August 21, 2019
Report: PG4720-LET.02 Revision 1

Subject: **Response to City Comments
Proposed Residential Building
89 Richmond Road - Ottawa**

TEMPEST LMF 60 ICD DETAIL

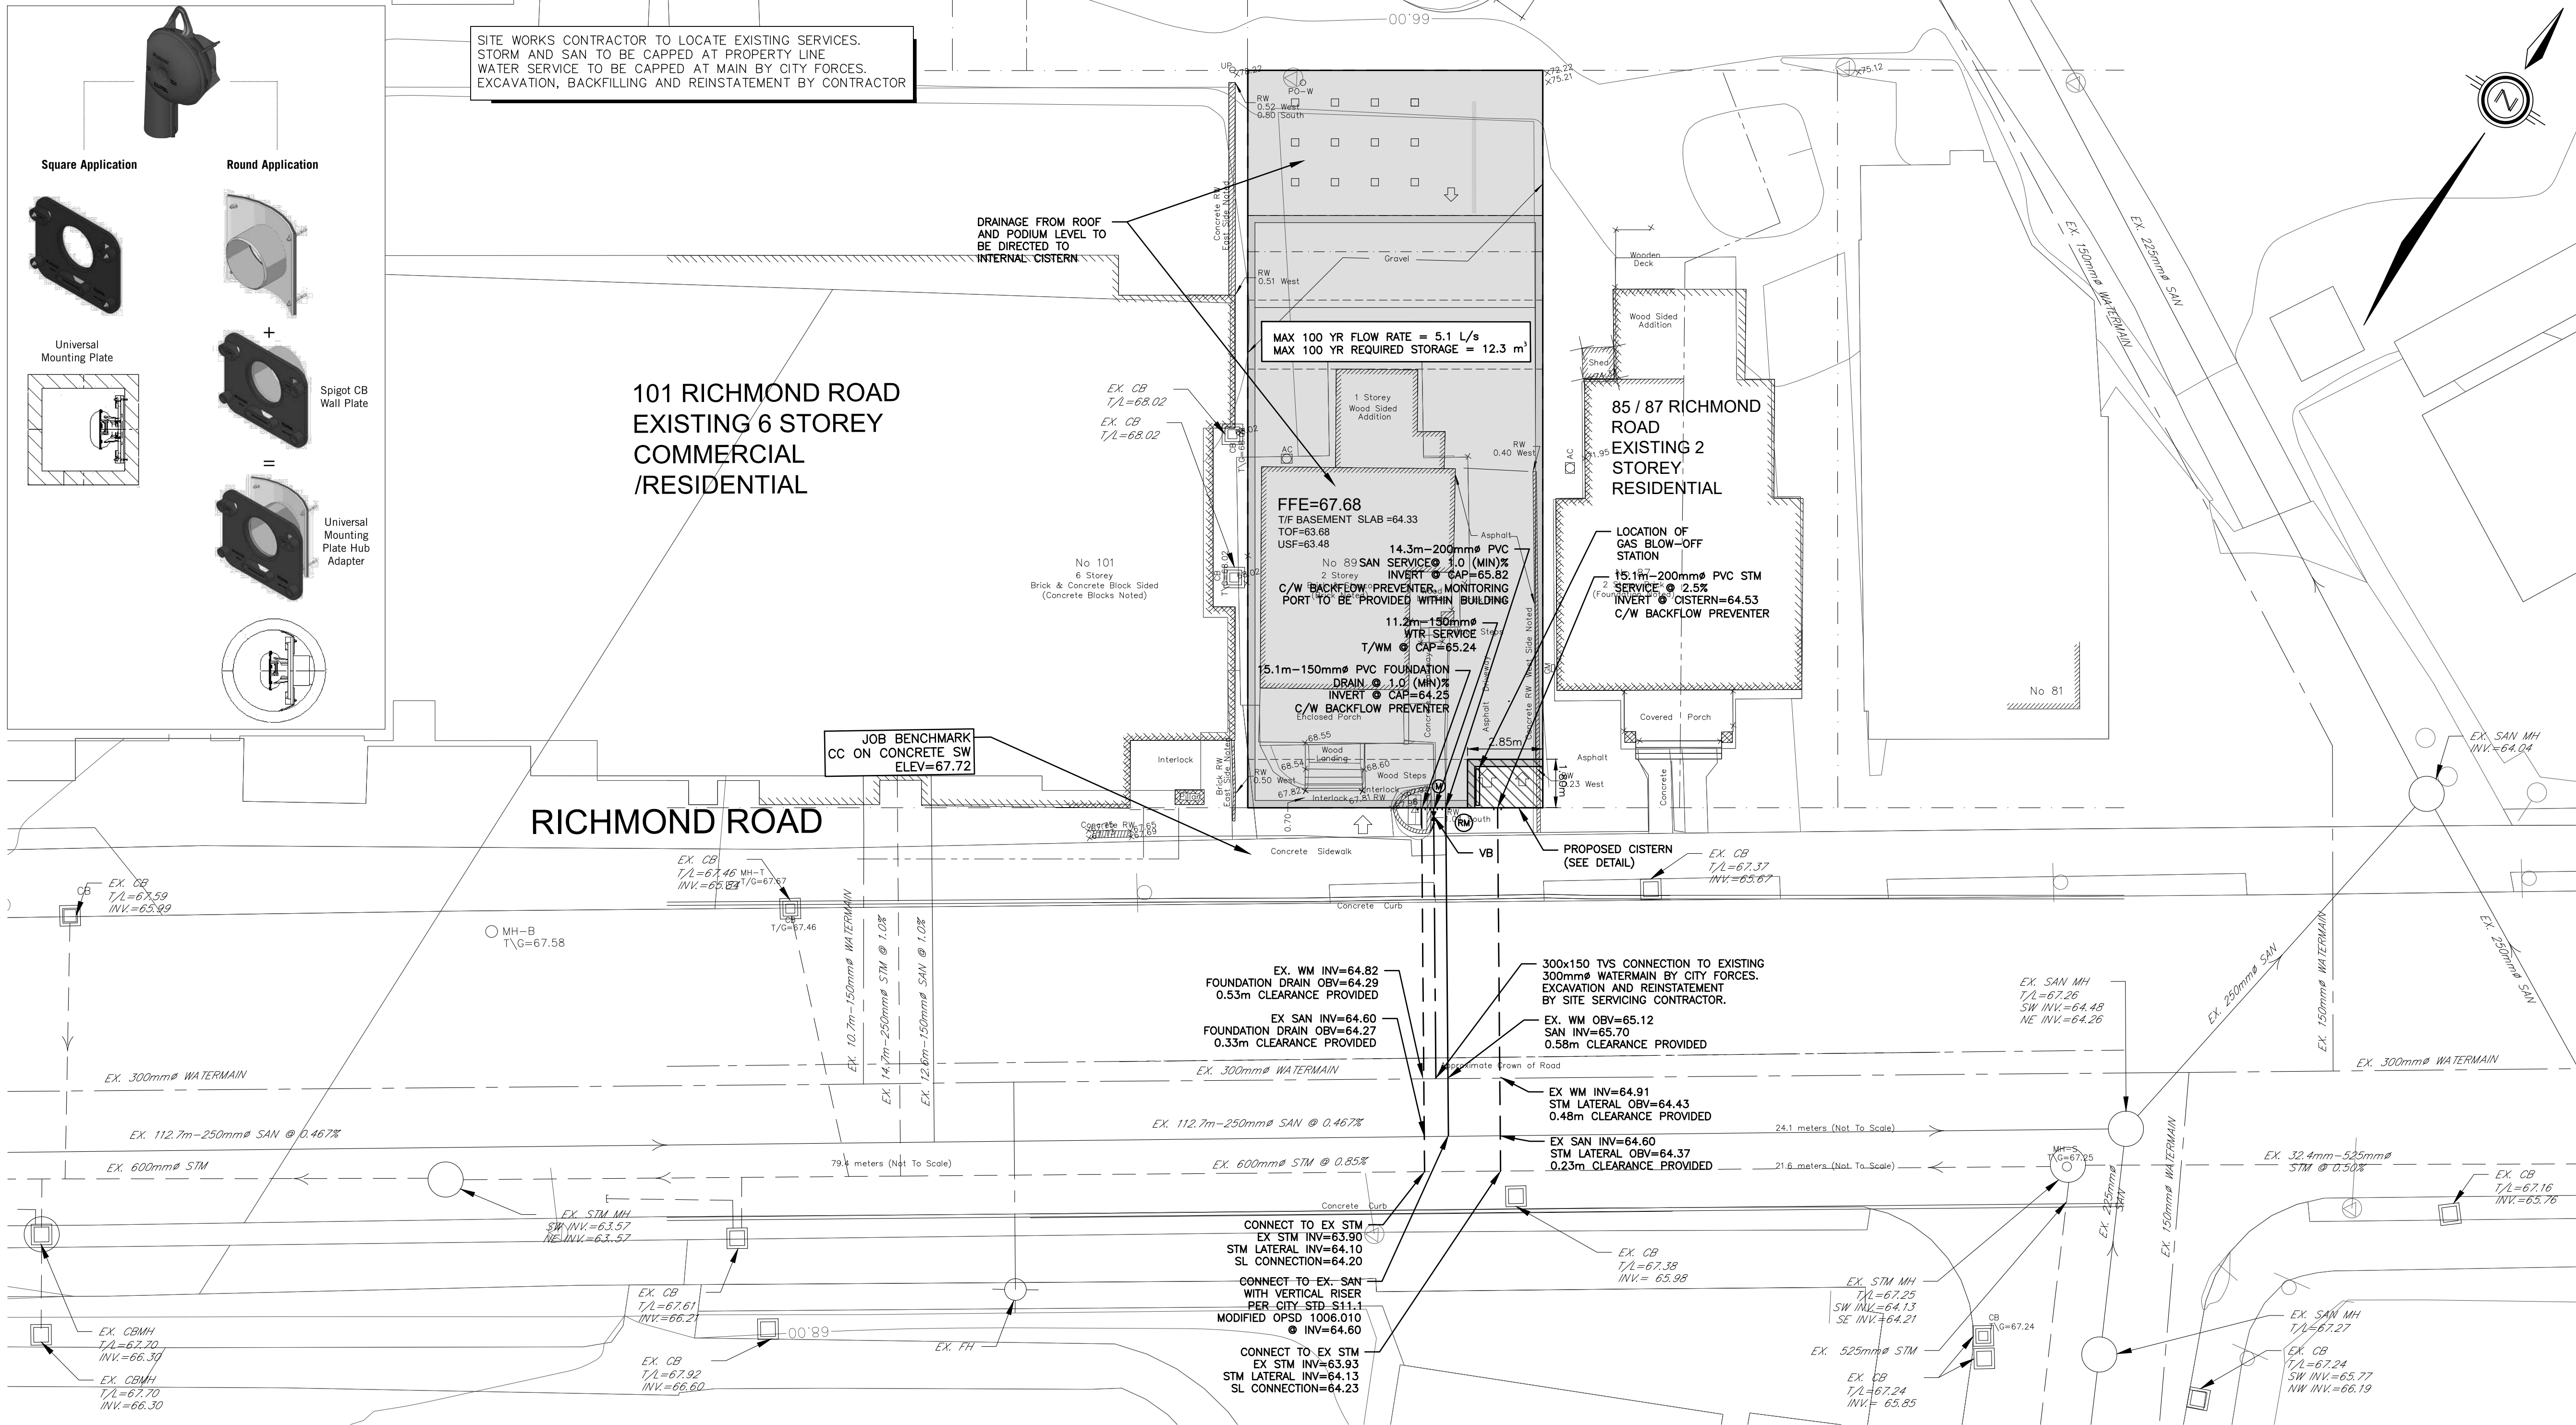
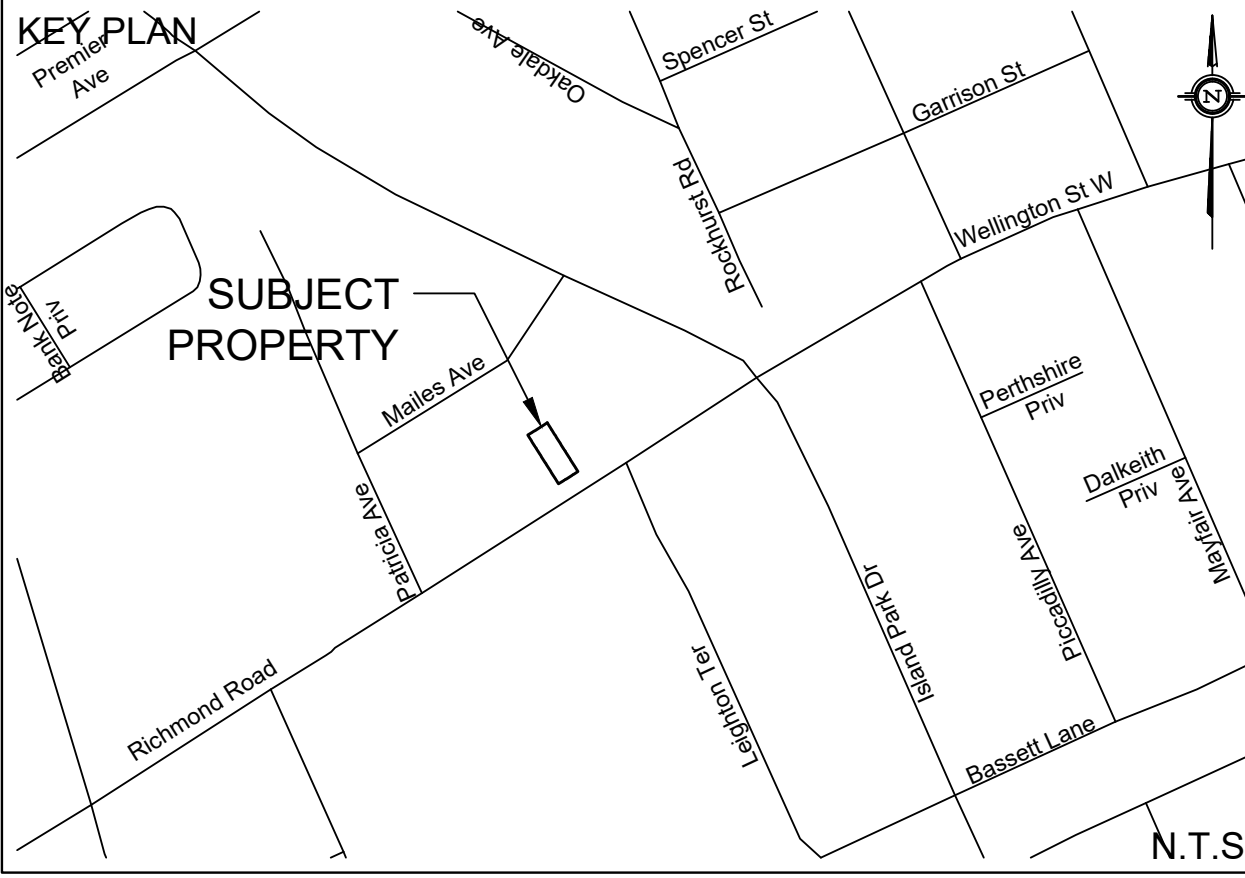
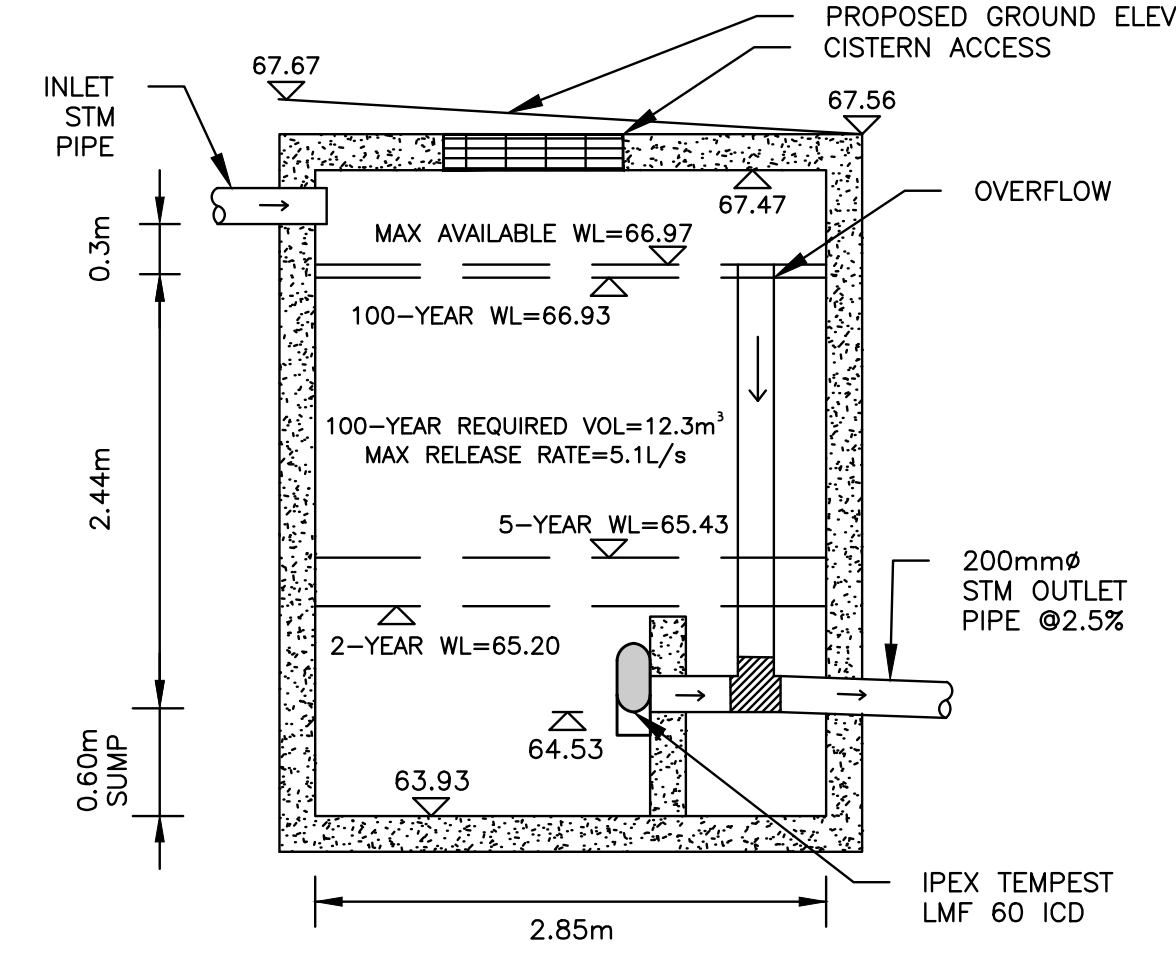
Geotechnical Investigation Report should speak to the underground stormwater storage system (cistern) proposed in respect to bearing capacity, foundation walls etc. We are currently unaware of the proposed cistern location and its construction details. Please obtain this information from the Mechanical and Civil Designers and revise accordingly.

The proposed development will have one (1) basement level that will be founded on a dense glacial till layer. The proposed cistern will be located in the southeast corner of the subject site, on the exterior of the proposed building. The loading of the cistern will be less than the excavated soil to accommodate the basement level and, therefore, will not produce any further settlements. The load of the cistern will not affect the foundation or foundation walls which will be founded on the bedrock. The long term groundwater level is anticipated to be below the slab of the cistern. Therefore, there are no uplift concerns noted for the cistern. In conclusion, the cistern is expected to perform in a satisfactory manner from a geotechnical perspective.
